Our Ref: BR/128/20/DOC

Approval of details reserved by condition imposed under BR/219/18/PL for condition 4-surface water drainage; 5-colour schedule of materials & finishes, 6-dustbin enclosures details; 7-electrical vehicle charging points, 8-incorporation of decentralised, renewable, low carbon energy supply system, 9-vehicular access details & 11-cycle parking space details.

9 Westloats Lane Bognor Regis PO21 5JZ

Project Proposed plans and elevations	Sheet
Date 30th April 2018	2
Scale 1 : 100 & 1 : 50

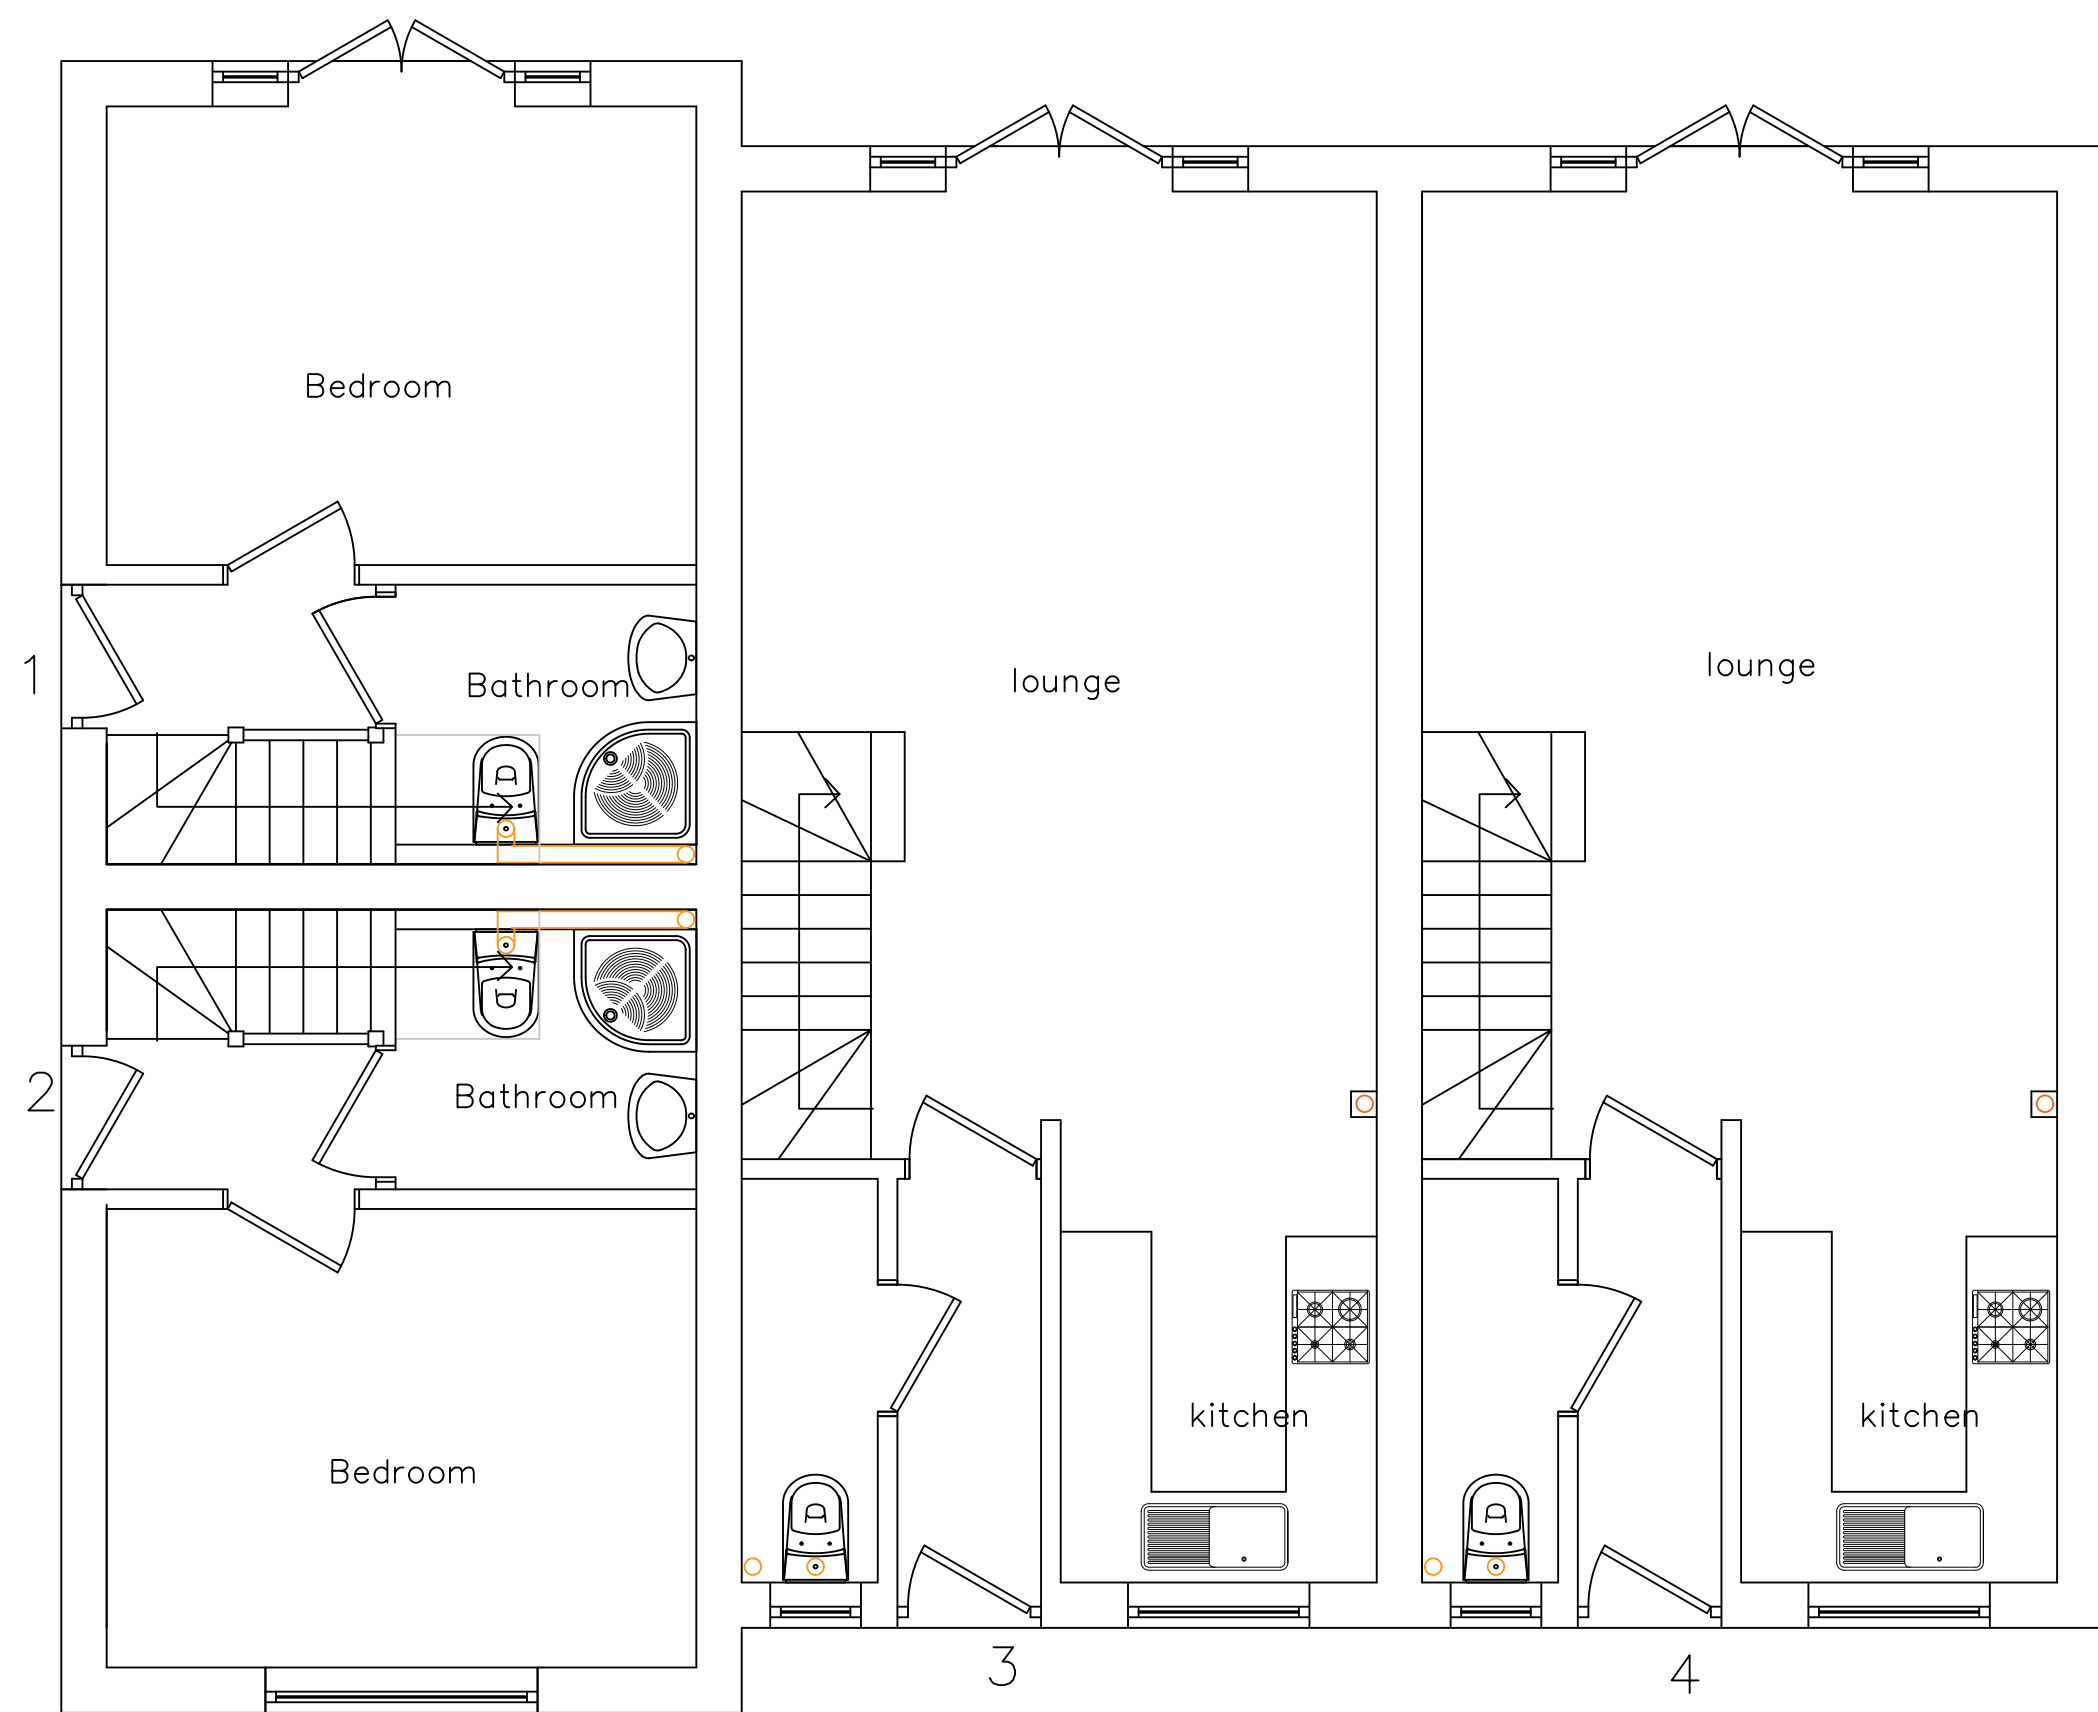
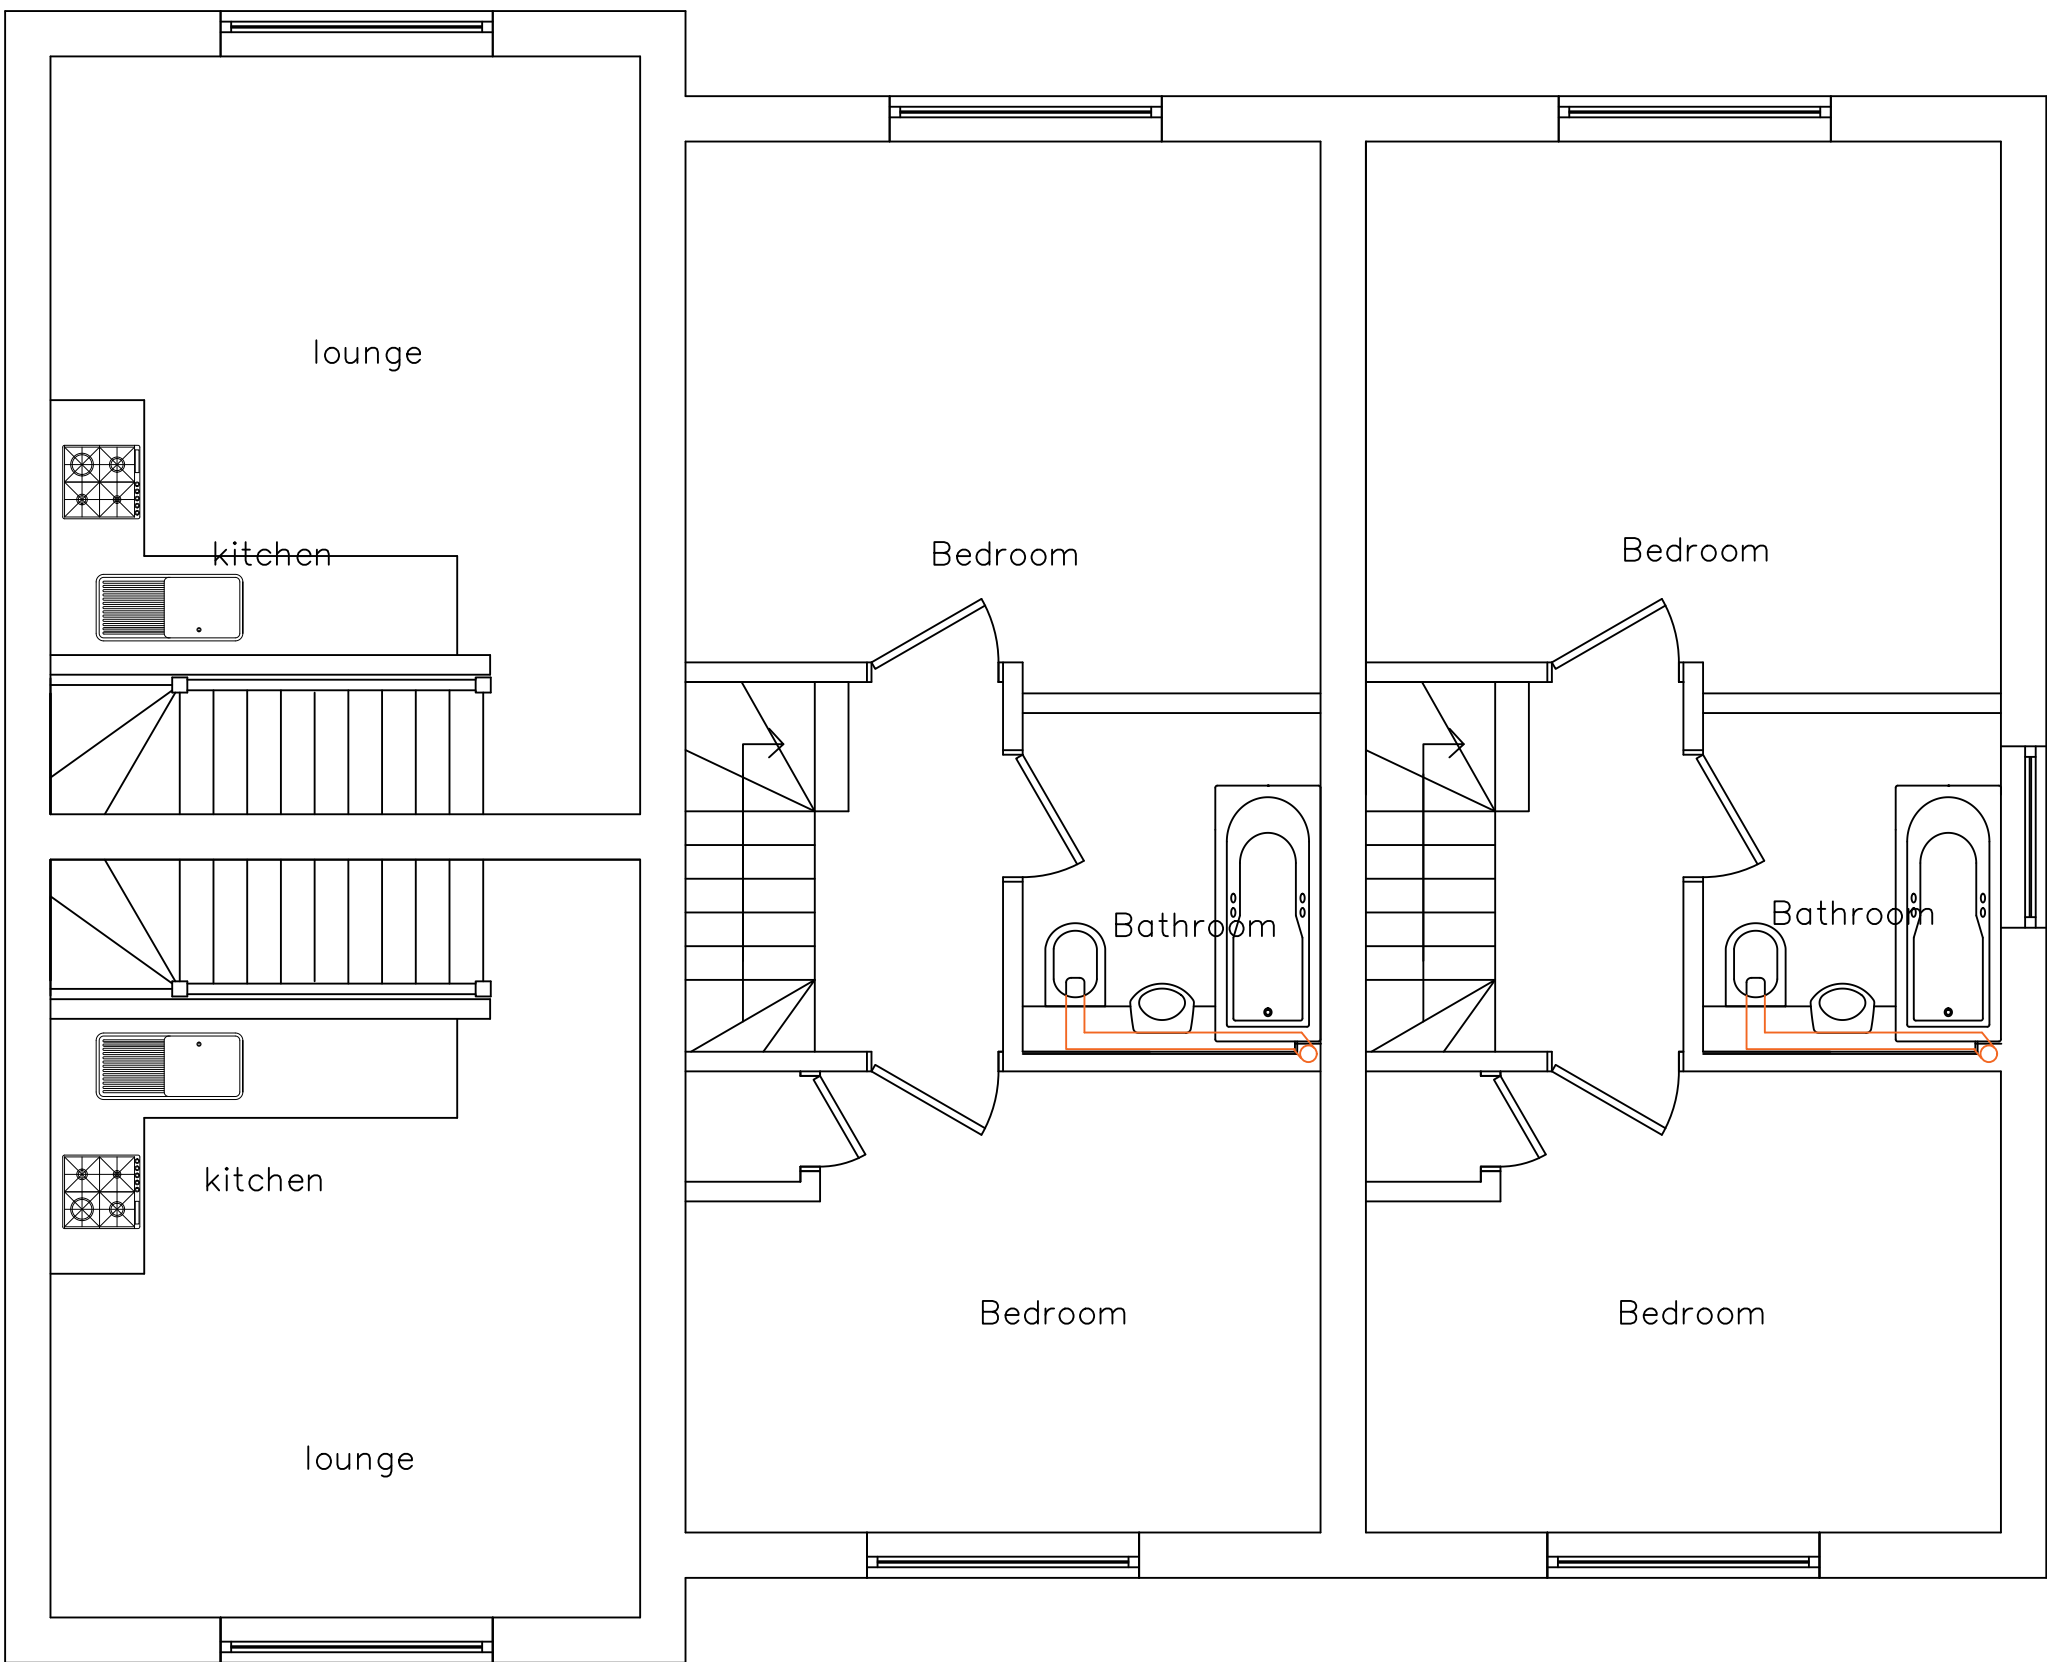
The details accompanying this application, namely the proposal to install photovoltaic panels to the south-eastern and south western roof plane as shown on the submitted Sheet 2 drawings is considered to demonstrate that the new houses will incorporate renewable energy supply systems.

The condition is fully discharged in so far as the submission of details relates and on the understanding that the photovoltaic panels will be installed on the proposed semidetached dwellings and permanently retained in a condition that is fit for purpose.
